February 9, 2026

**Re: Take 5 Oil Change at 2030 Gibson Blvd SE
Erosion and Sediment Control Plan
Engineer's Stamp Date – 2/4/26 - M15E021E – (SWQ-2026-00003)**

James D. Hughes, P.E., CPESC
Principal Engineer, Planning Dept.
Development and Review Services

LOVELACE HEIGHTS ADDITION CITY OF ALBUQUERQUE 2030 GIBSON BOULEVARD	
EROSION CONTROL DETAILS	
DESIGN REVIEW COMMITTEE	CITY ENGINEER APPROVAL
ZONE MAP NO. M-15 & L-15	
CITY PROJECT NO.	
SHEET NO. C3.2	
PAGE 3 OF 4

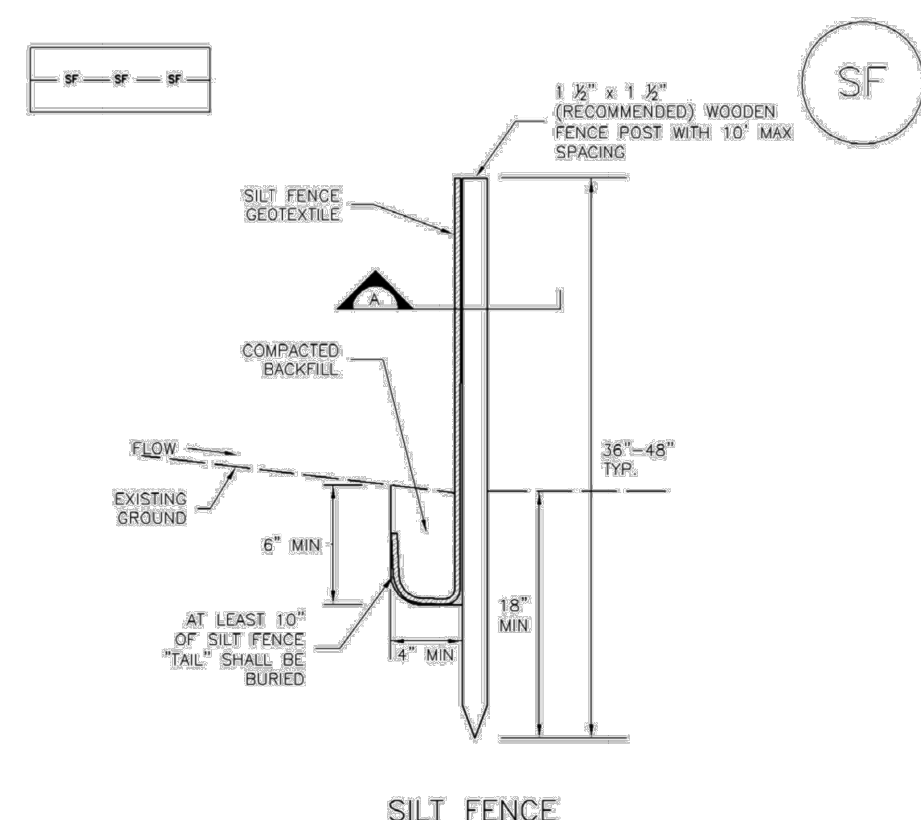
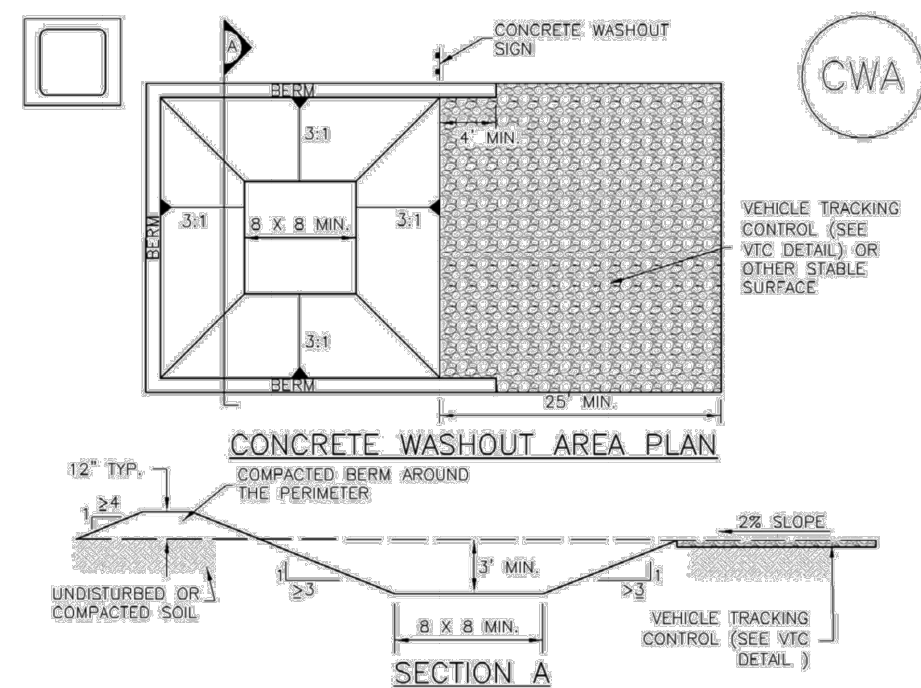
5. The Colorado “Urban Drainage and Flood Control District” BMP details on sheets C3.2, C3.3, and C3.4 are blurred and unreadable. The design specifications required by NMED at CGP 9.6.1.c are missing. The ST detail on Sheet C3.4 shows embankments and rock dams that contradict the design specifications and limitations on the city detail (attached). Replace the unreadable, incomplete, and misleading details.
6. An updated version of the city standard notes is attached and will apply to this site.
7. Update the engineer’s stamp date on all sheets whenever a plan changes on any sheet to reflect the engineer’s review of the impact across all sheets.

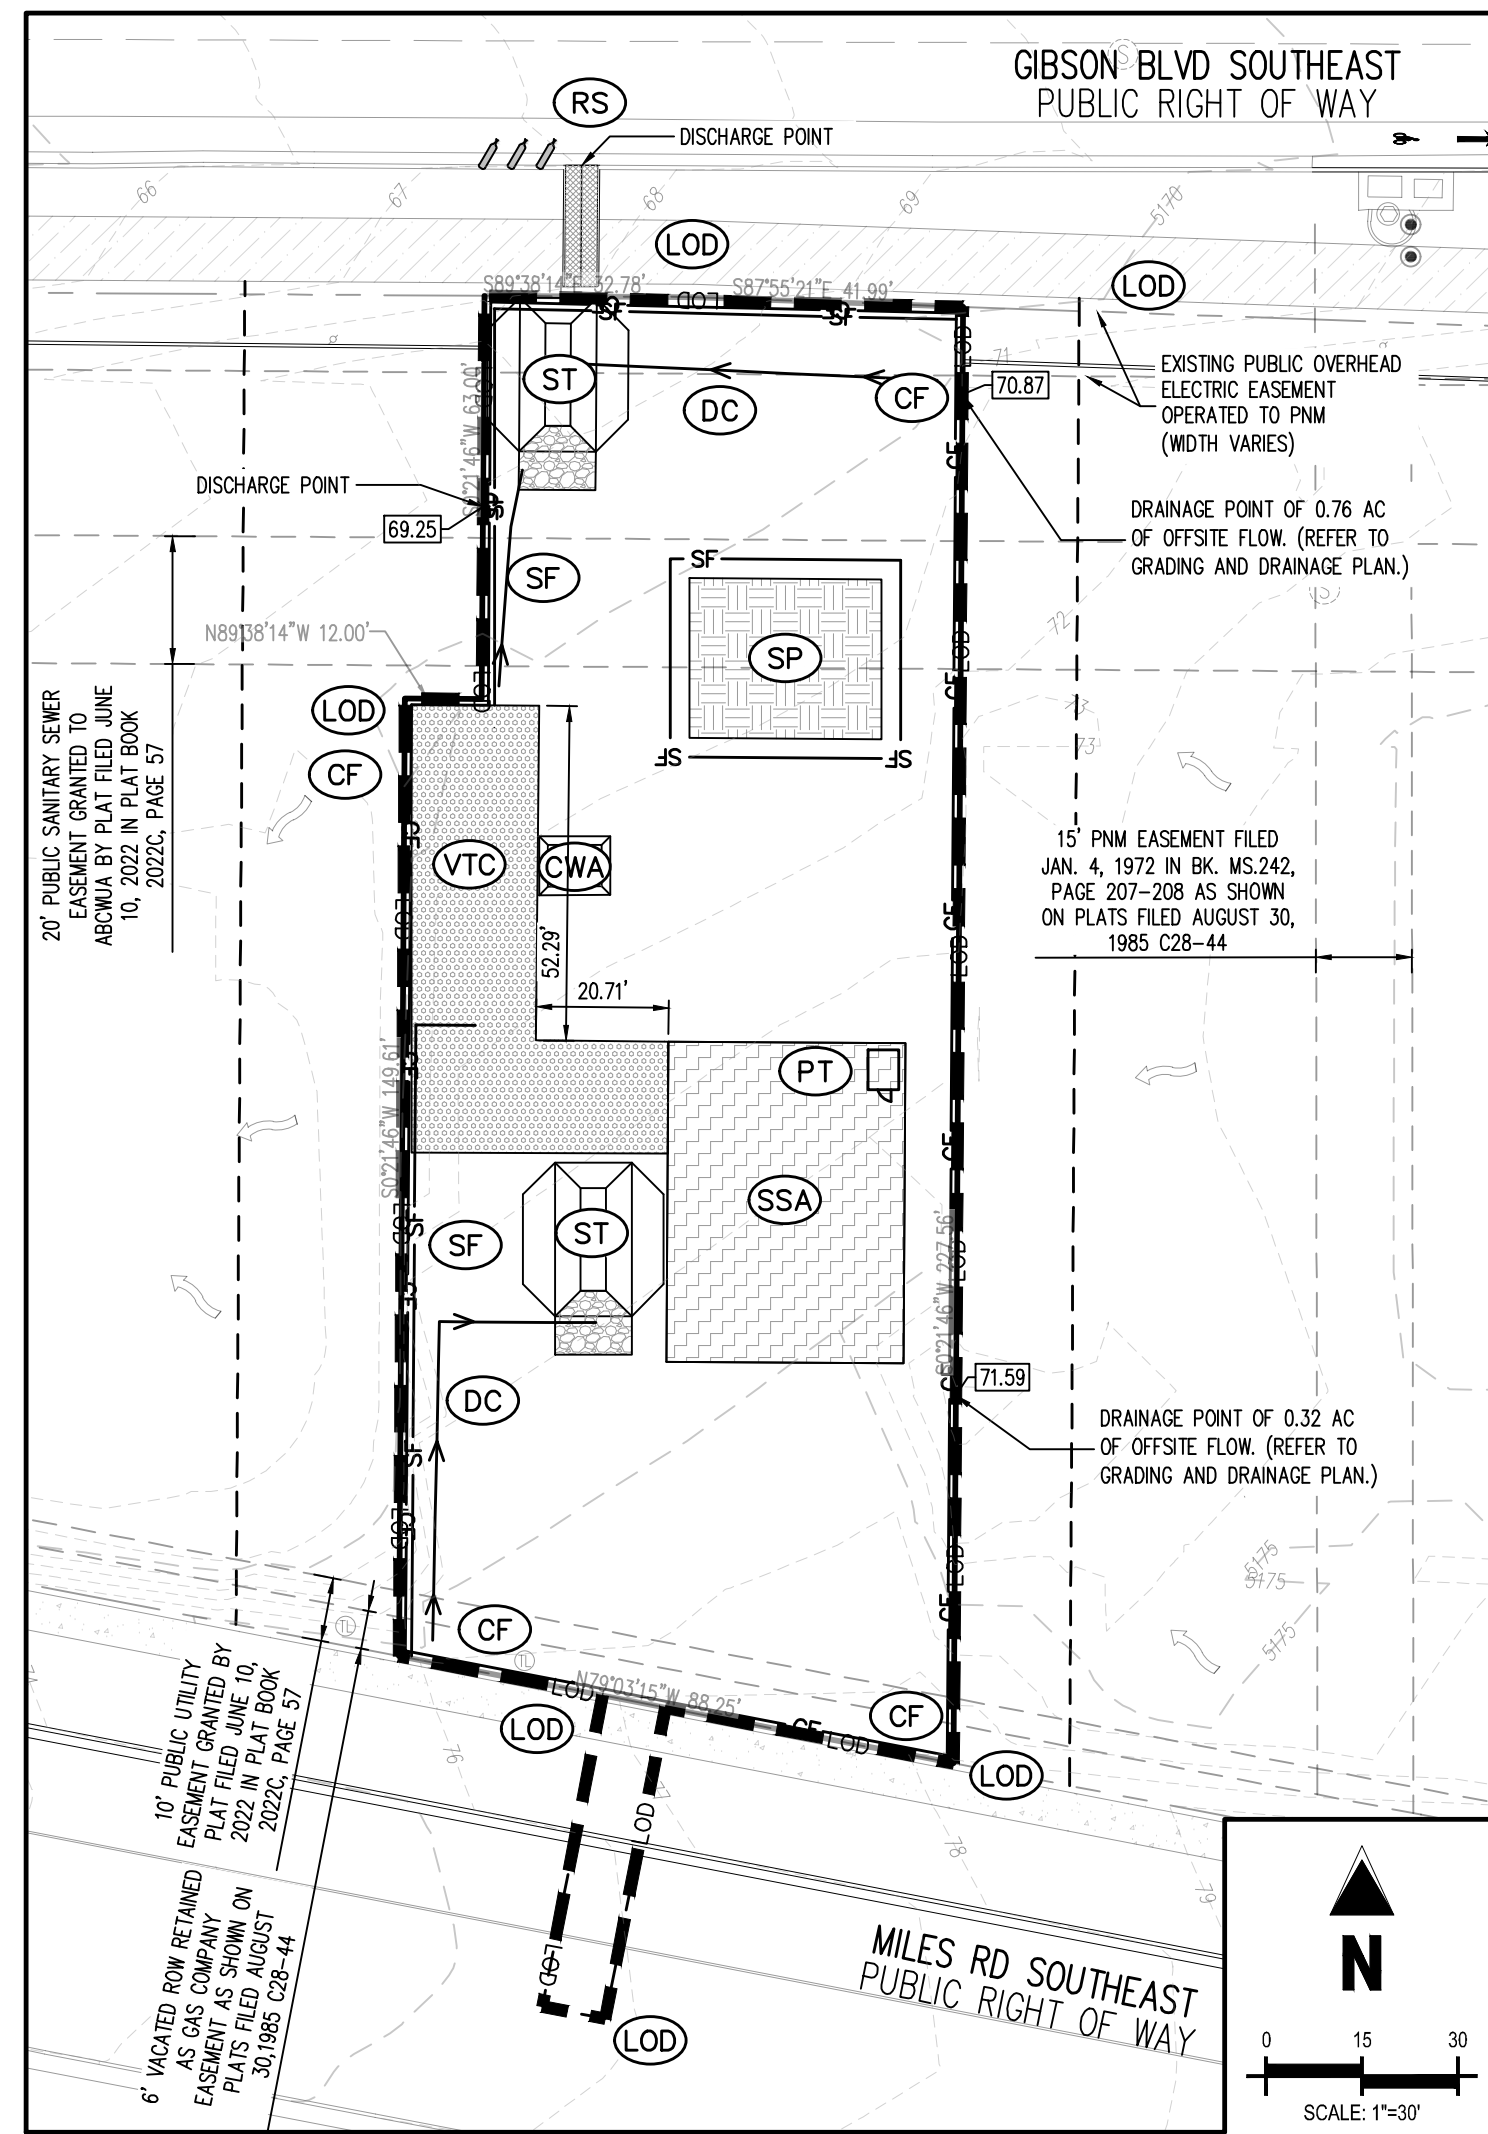
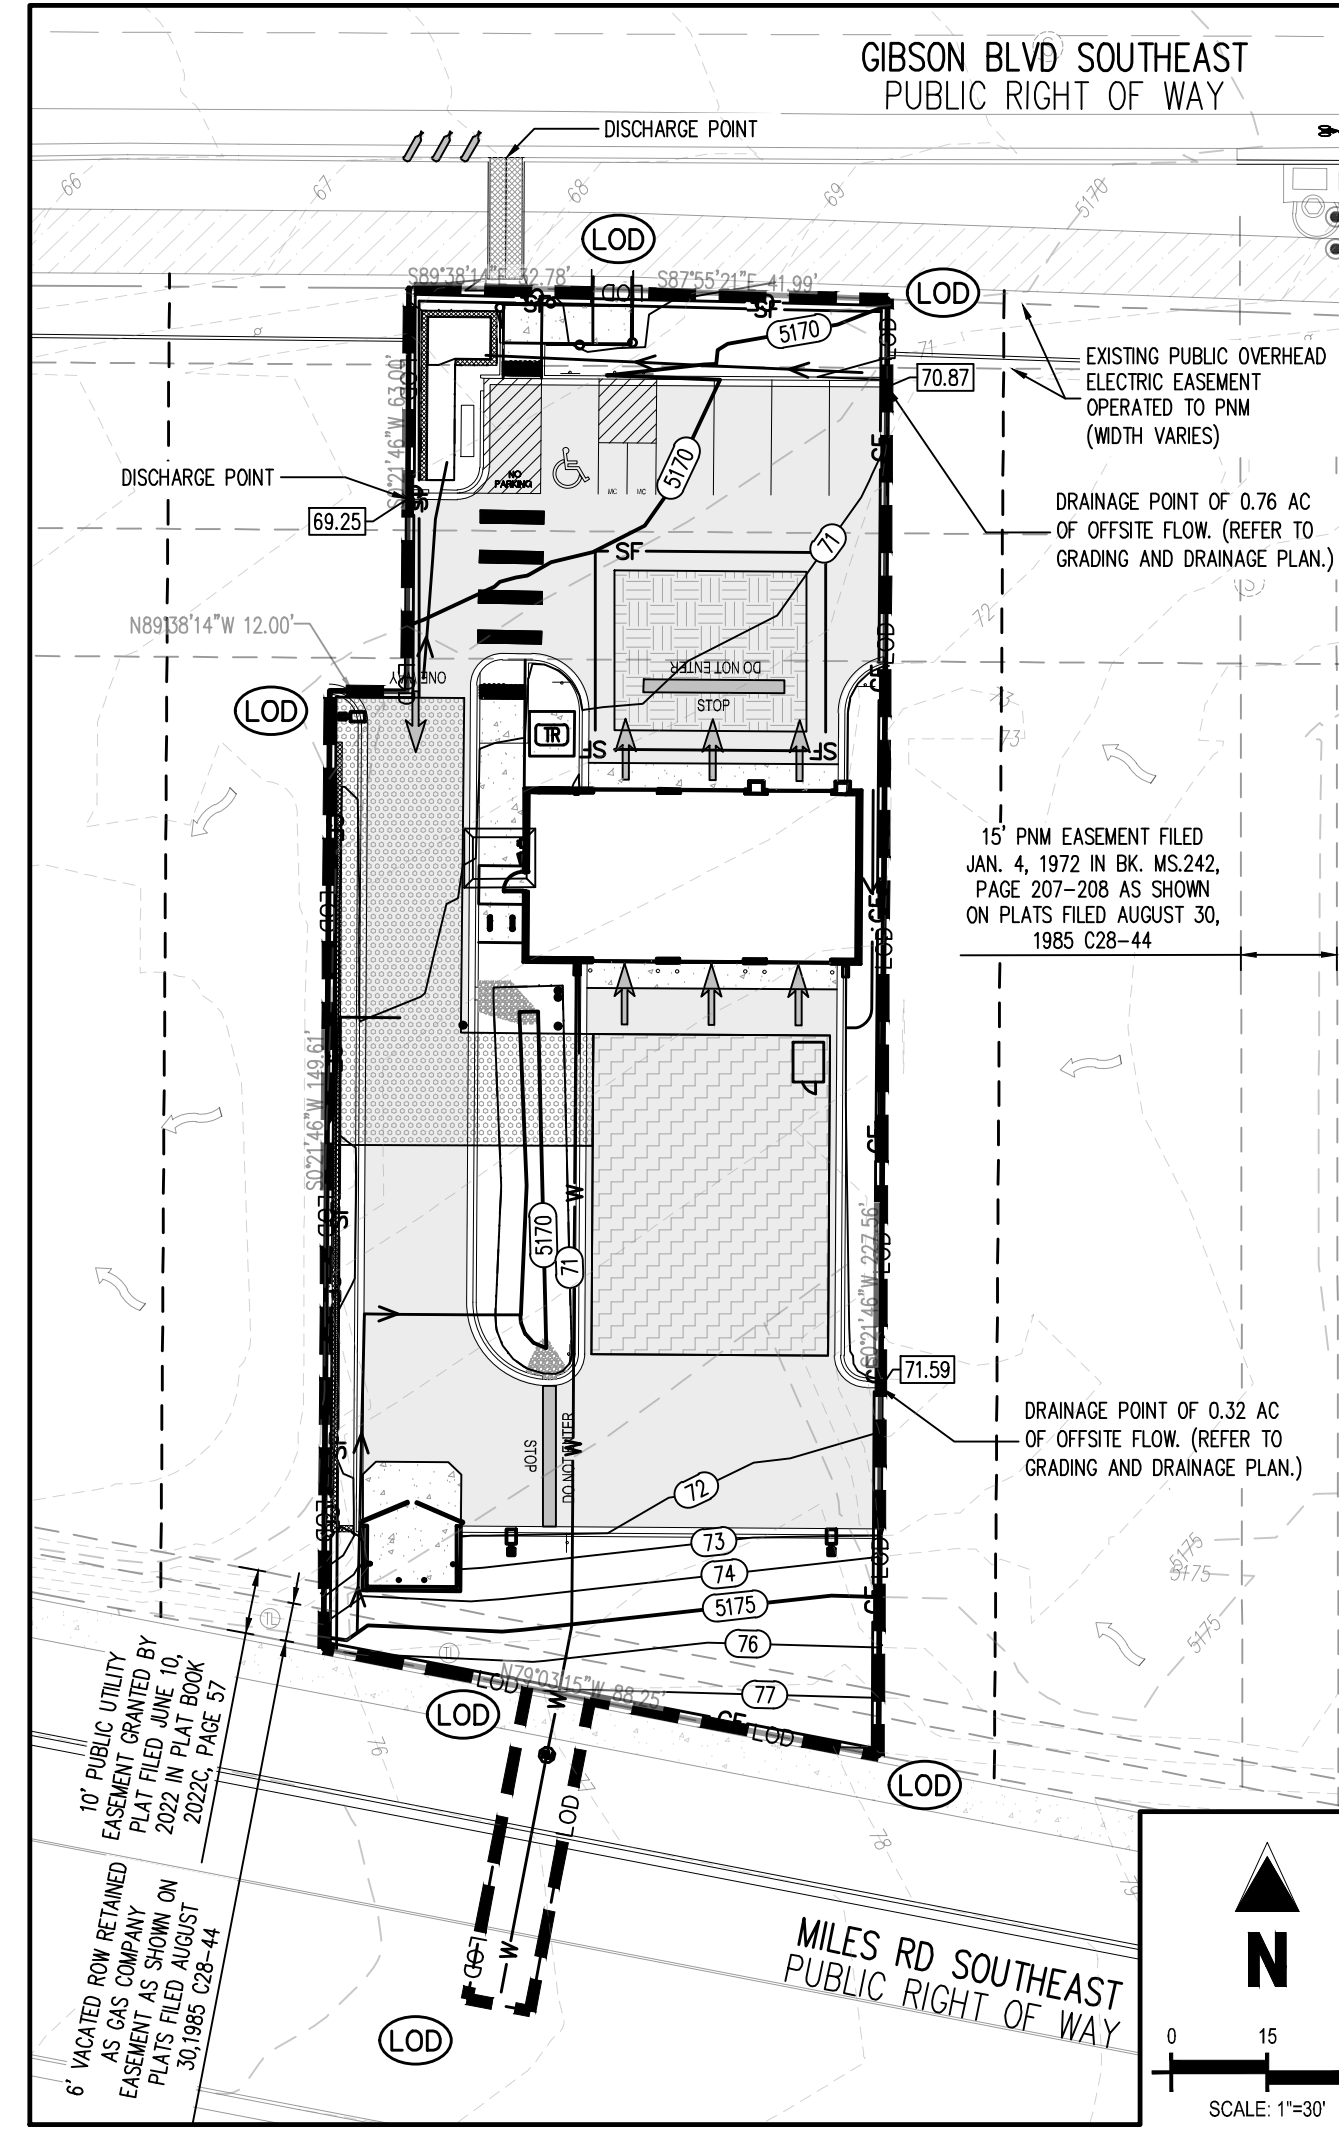
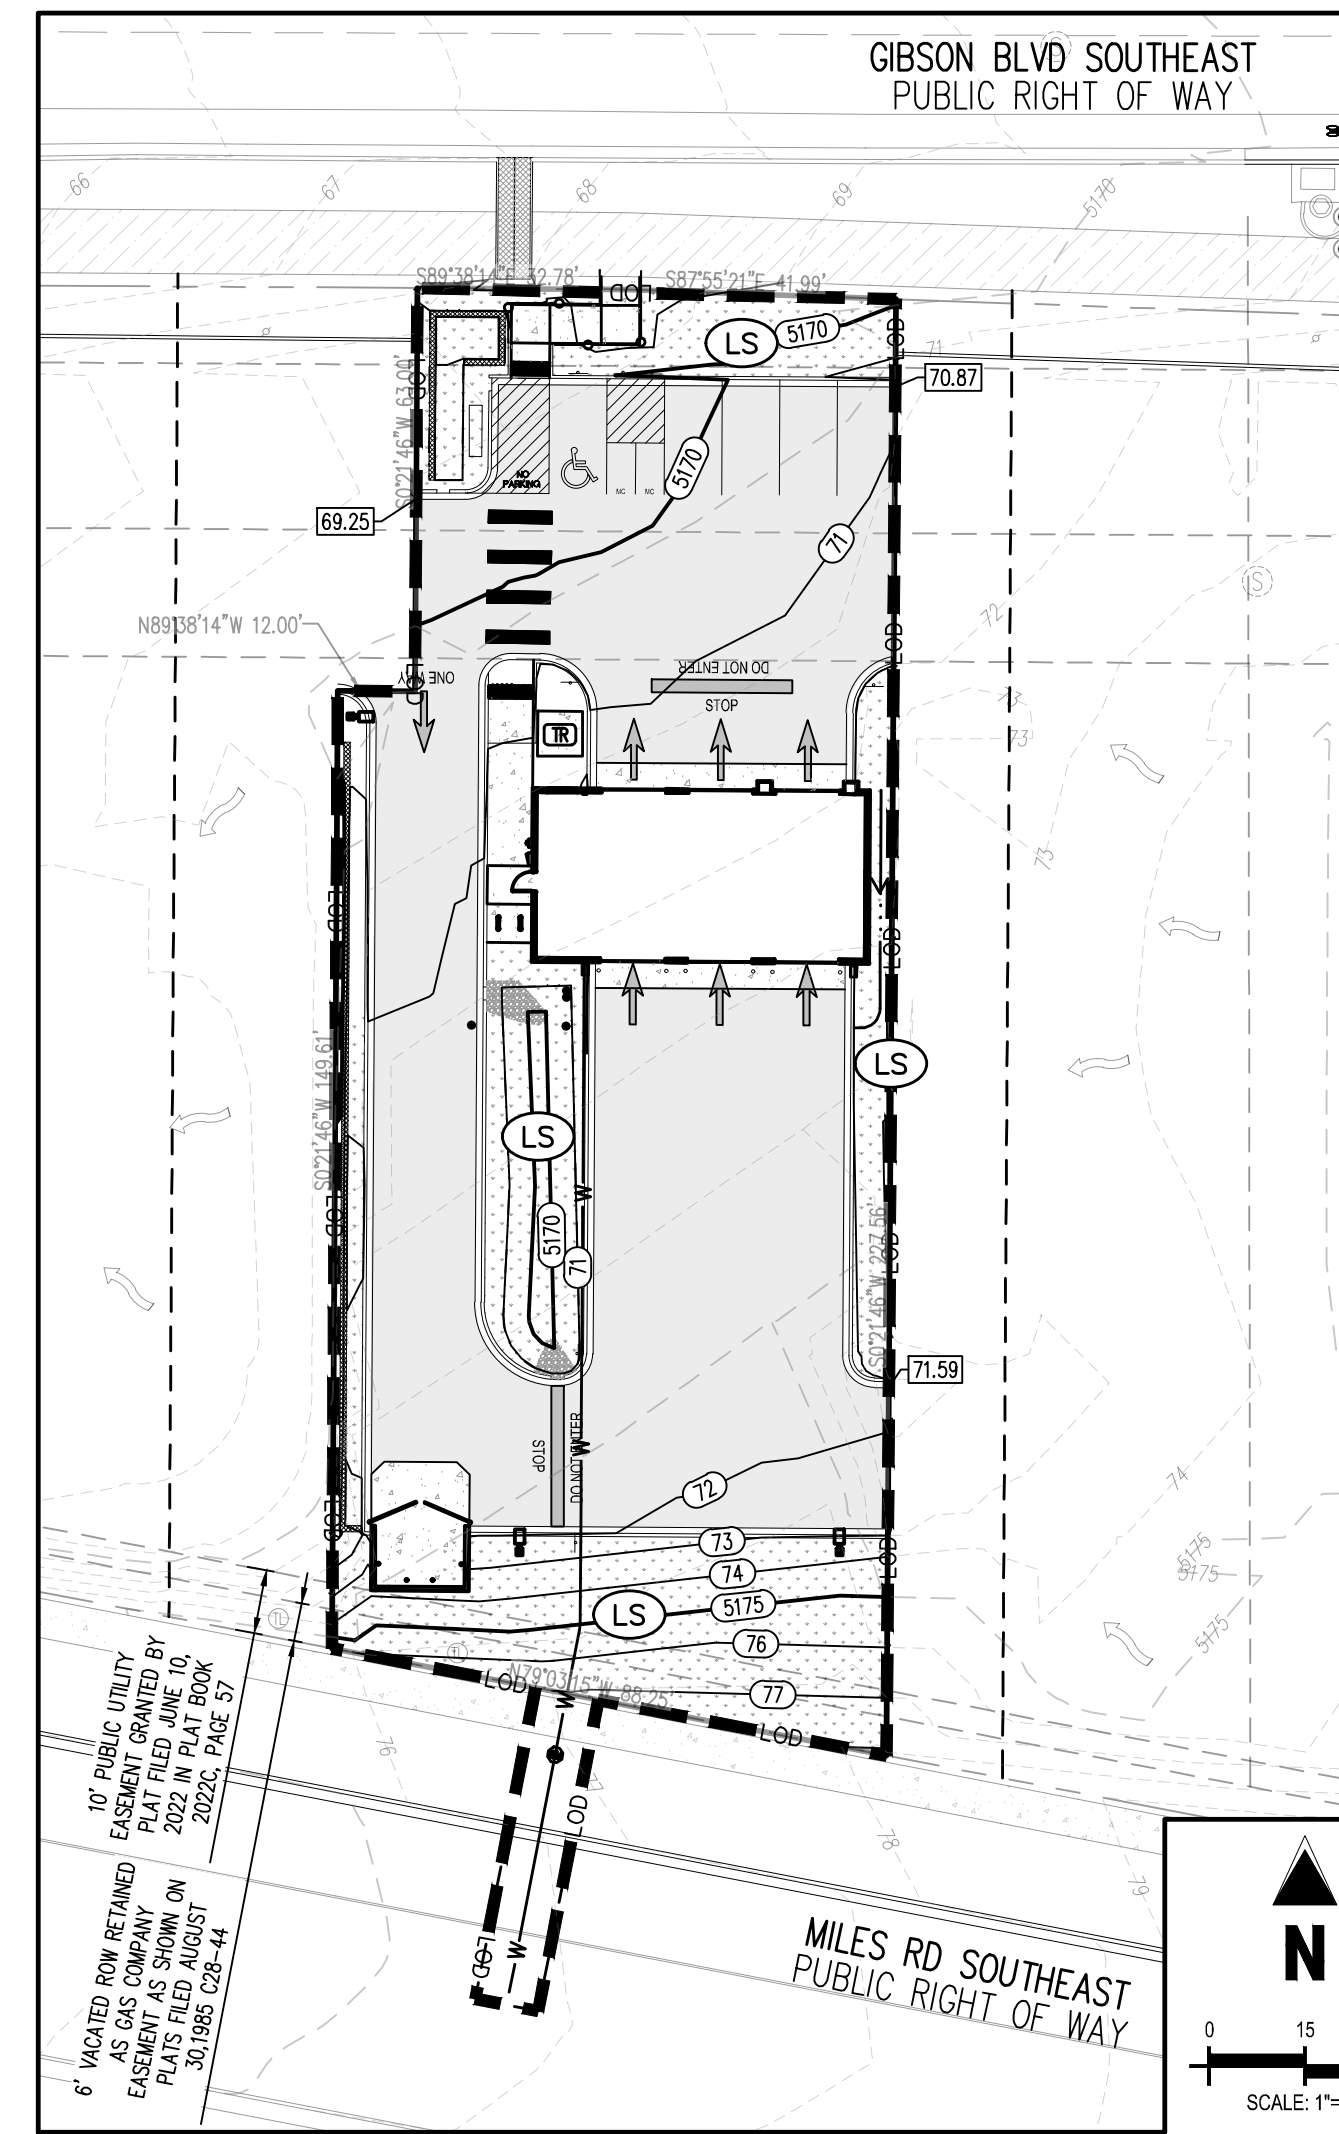
3. Add the temporary ST and DC as the first item in the construction sequence on sheet C3.0 and removal of the ST and DC as the last items after construction and stabilization. Change the note below the table to say "this is the only schedule allowed by the city," instead of footnote 2, which refers to another schedule in the SWPPP. Similarly, the temporary STs must be added to the interim condition on sheet C3.1. Sediment traps may overlap into the parking lot until the rest of the site is constructed and stabilized because the required volume is far larger than the post-construction volume.

4. Provide Diversion Channels (DC) along the low side of the site using the attached city detail to direct stormwater into the Sediment Traps. The existing retaining wall along the west property line may serve as a temporary BMP instead of the DC, provided it is inspected and maintained during construction, along with the other BMPs. A diversion is also necessary across the east/west drive aisles to prevent basin 104 from draining off-site during construction. Provide additional construction notes on the ESC Plan and add the DC detail.
